MEMORANDUM

Project No.: 24-0388

EPC Project Number: PPR2315

Business Park 2- Drainage Compliance Letter

C5.2

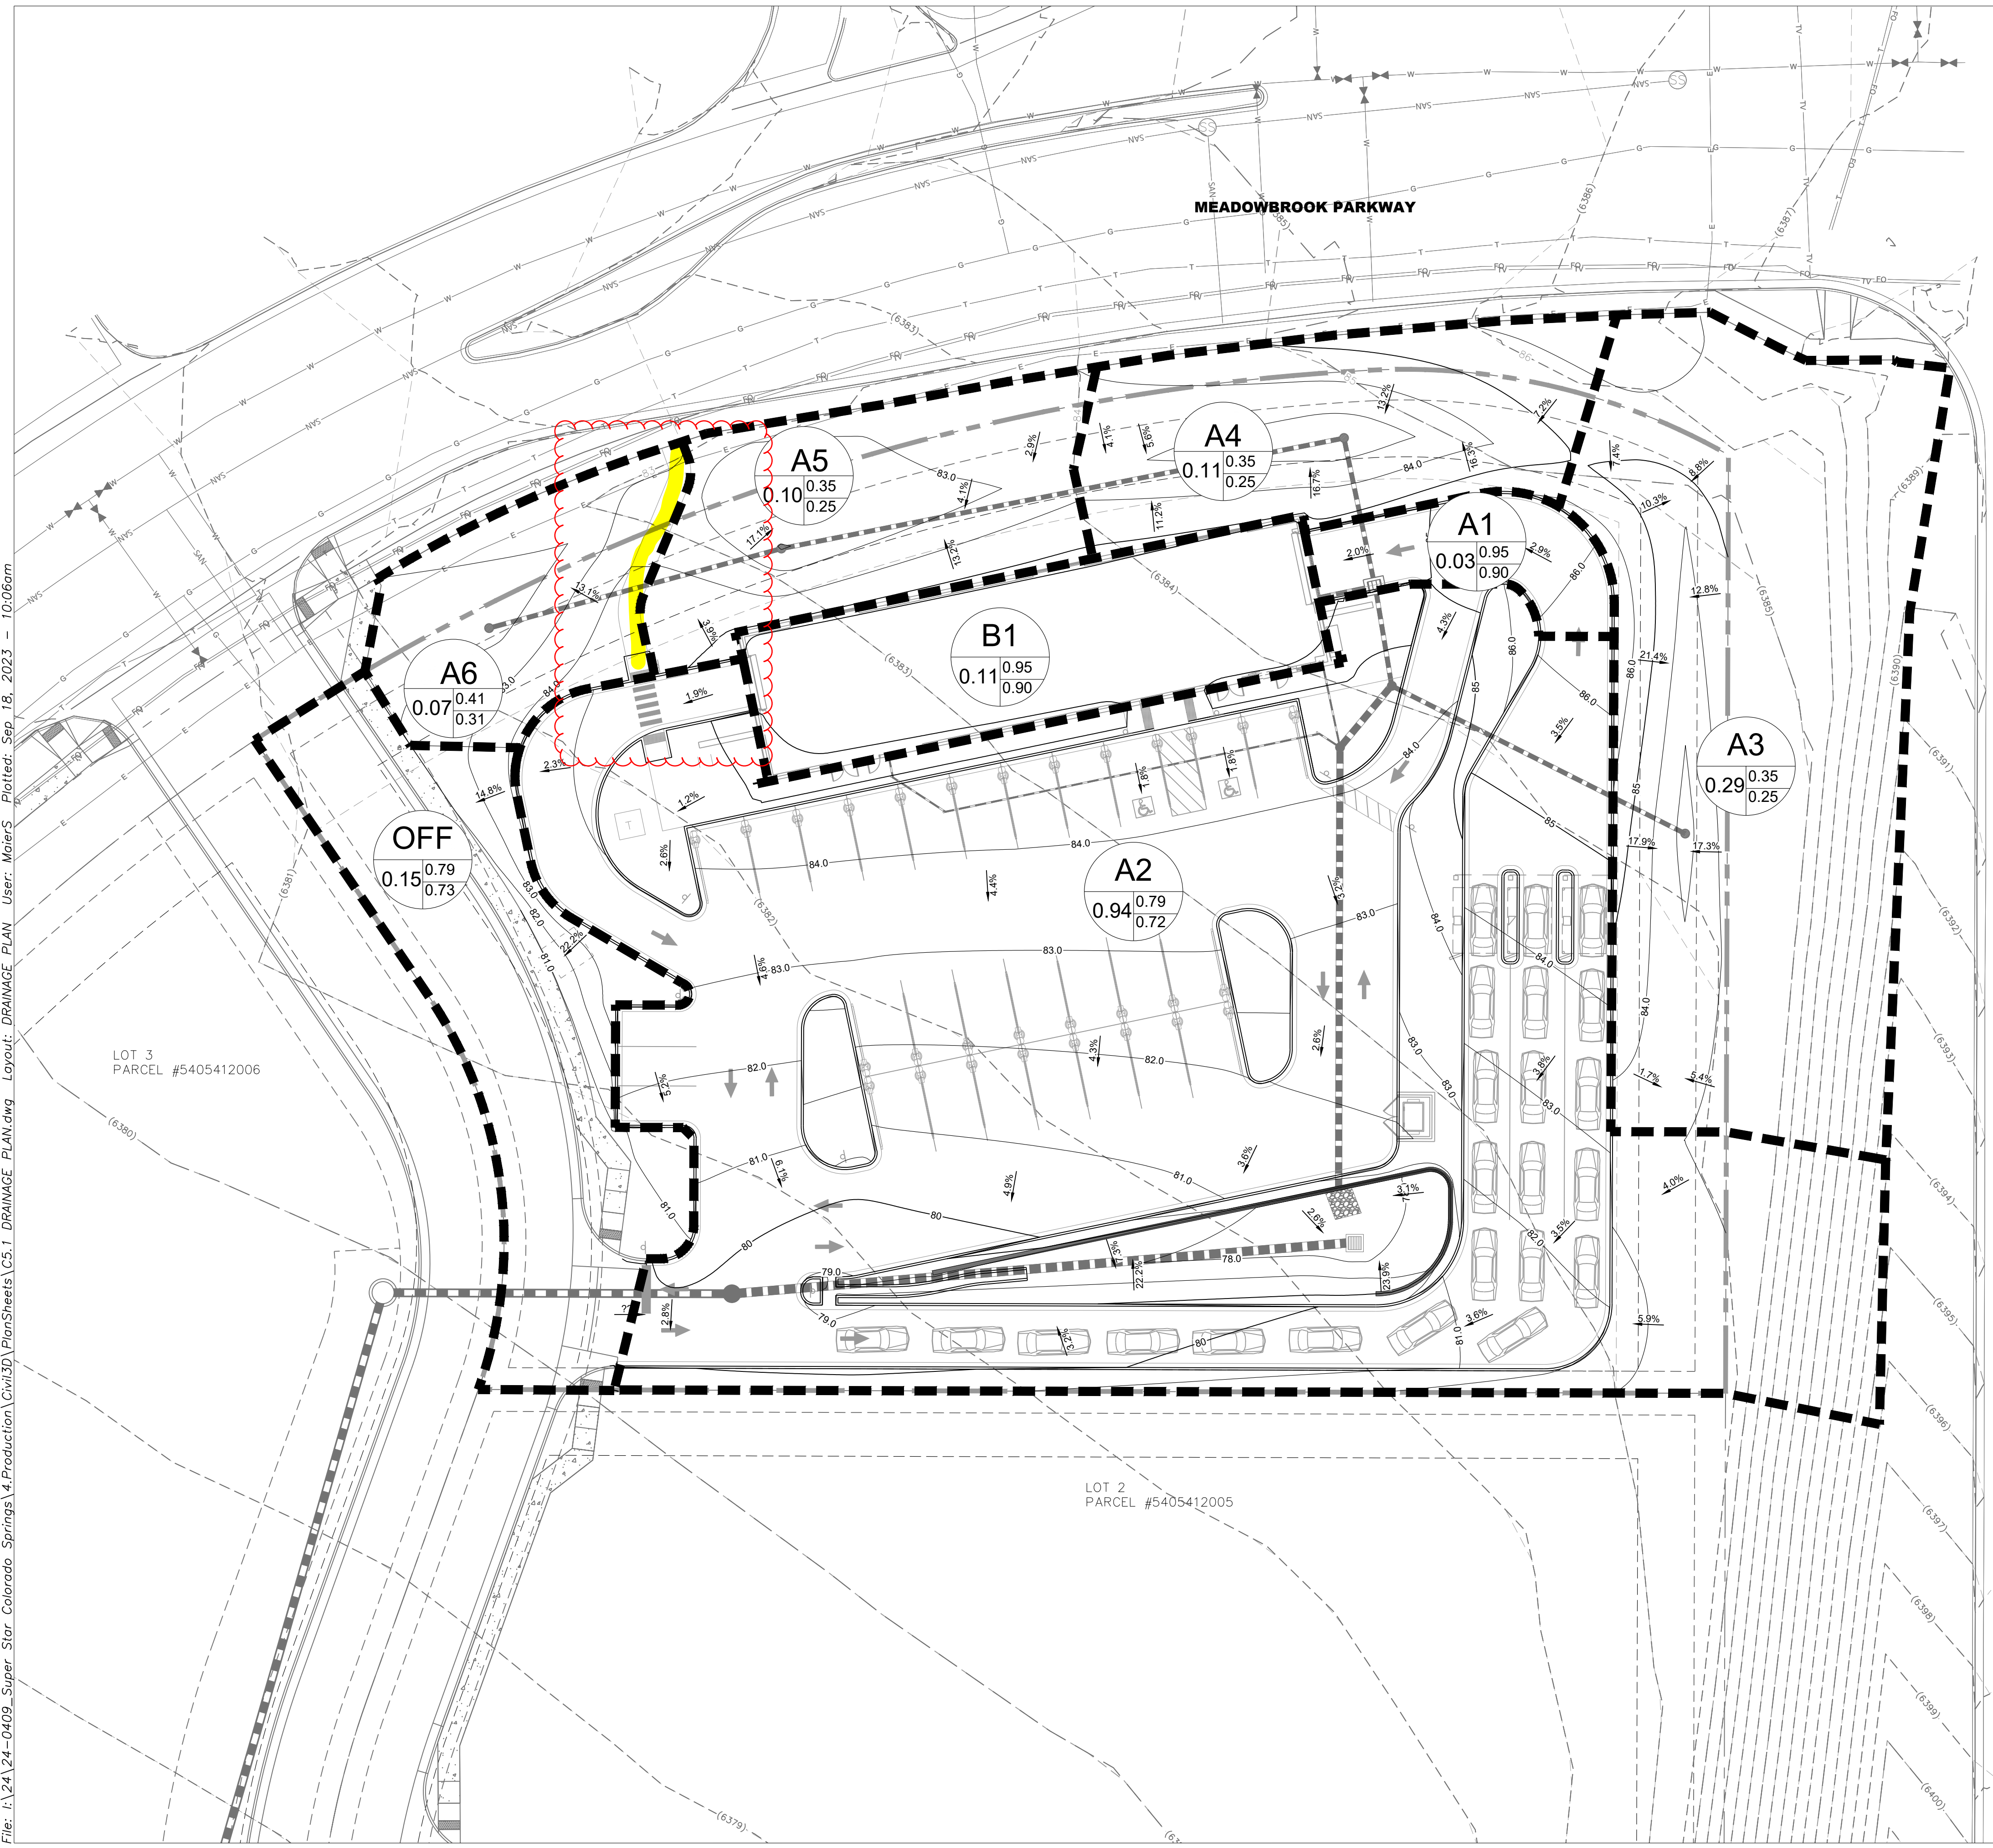
Please label all storm facilities

Provide in the text of your report a narrative description of the proposed sub-basins. Identify the appropriate design points as well.

Label all storm drains and provide flow arrows to all watersheds to clearly show drainage patterns.

account for offsite flow entering the site

Where does the runoff in the highlighted section go? It appears to collect on the back of the proposed curb. If this never combines with the rest of A2 this should be its own basin and will need to have WQ accounted for.

The runoff coefficients provided do not match coefficients in table 6-6 of the County adopted Chapter 6 of the 2014 City of Colorado springs DCM. please revise all coefficients accordingly to match. See link below
https://library.municode.com/co/el_paso_county/codes/drainage_criteria_manual?nodeId=VO1UP
